From: Janice Chapman
Sent: 08 October 2013 08:54
To: Planning Scanning
Subject: FW: P/74/13
Attachments: road view 1.JPG; verges road view 3.JPG; verges road view 4.JPG; front 2 lagoon rd.JPG; front 2 lagoon rd.JPG; front 2 lagoon rd.JPG

From: [REDACTED]
Sent: 07 October 2013 16:47
To: Janice Chapman
Cc: paghampc (Chris Braby)
Subject: P/74/13

Further to my letter dated 13th September objecting to this Planning Application on several grounds, please find attached photos in support of my objection to the rear boundary wall. As you can see, the proposed wall would be adjoining the roadside, when in fact it should be several feet back, there should be a natural hedge abutting Well Road as per my photographs.

REAR WALL & GARAGE

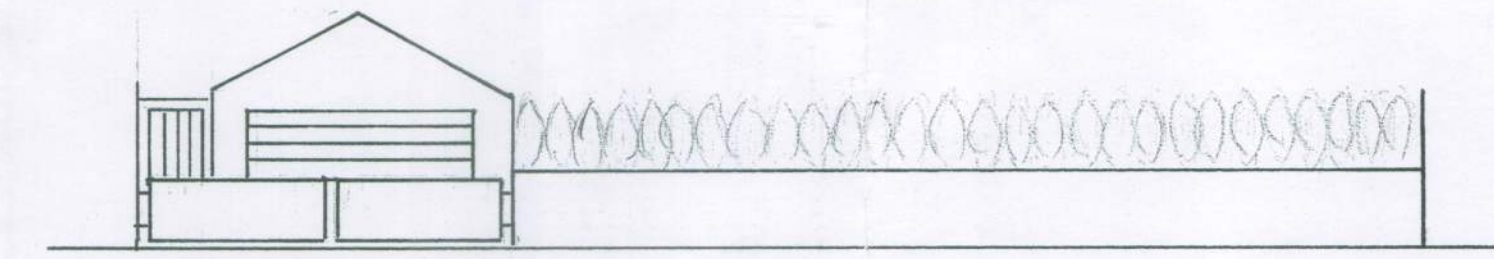
As to the "horrendous closely built up appearance of Well Road", surely a wall built directly adjoining this road would only add to the "horrendous, closely built up appearance"!!

SITE PLAN 1:200

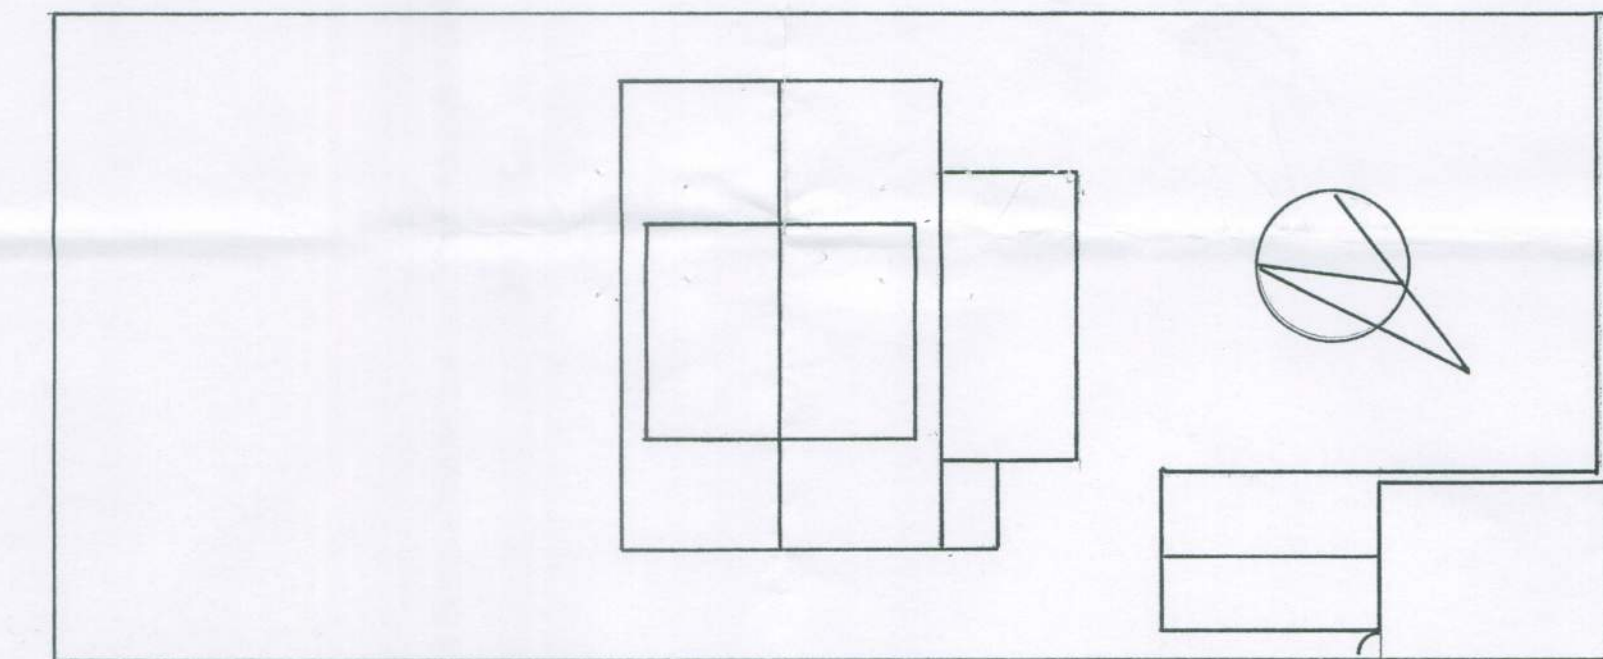
Could you also please clarify the proposed access to the new garage? It appears to be from Well Road but there's already an existing driveway from Lagoon Road. (as per photo). Access from Lagoon Road would be the more neighbour friendly option, especially as there's an ongoing land dispute with Pagham Beach Holdings Ltd.
